Development Facilitation Team (DFT) – Review Comments

Project No: PR-2024-010846 Date: 6/25/2025 Agenda Item: #3 Zone Atlas Page: K-16

Request: Amended Vacation of Right of Way currently used for parking on Bryn Mawr.

Application For: VAC-2025-00027 – AMENDED VACATION OF RIGHT-OF-WAY

SITE PLAN

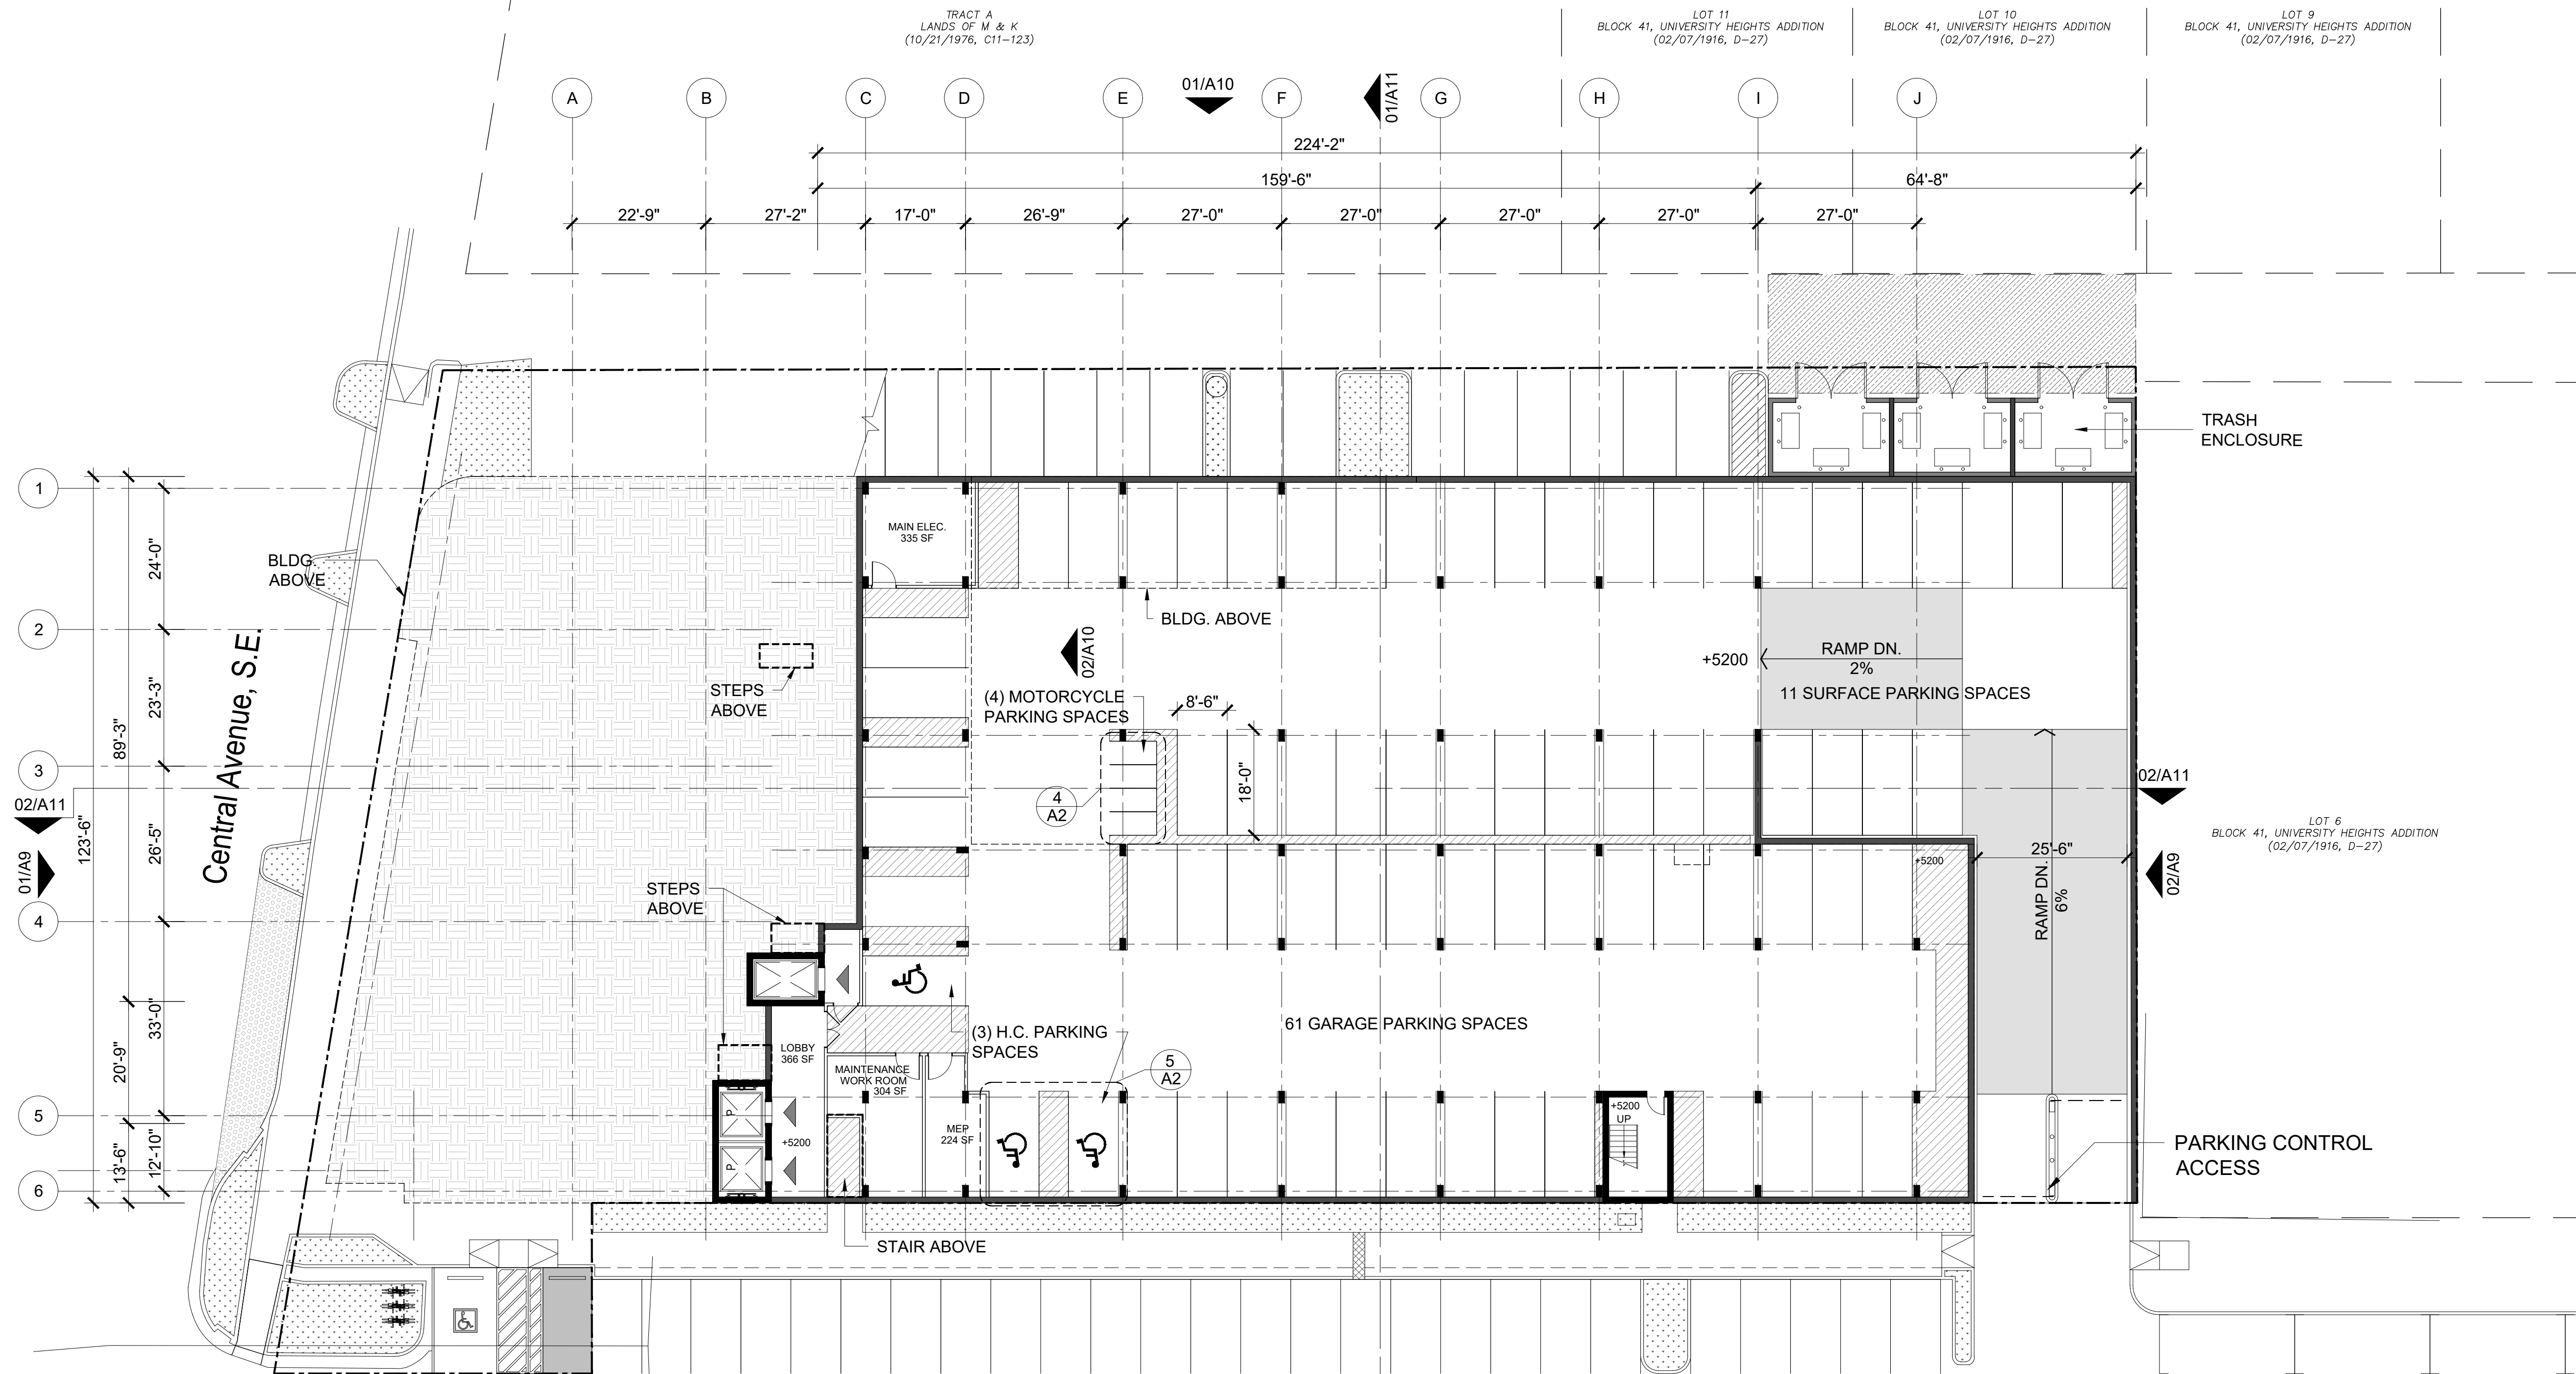
2. The alleyway on the east side shows a 16' width. All alleys are required to be 20' wide. If you are unable to provide this you may request a determination with a justification letter.
3. An approved TCL will be required prior to site plan or building permit. Also, please fill out and submit a Traffic Scoping Form to determine if a traffic study will be required.
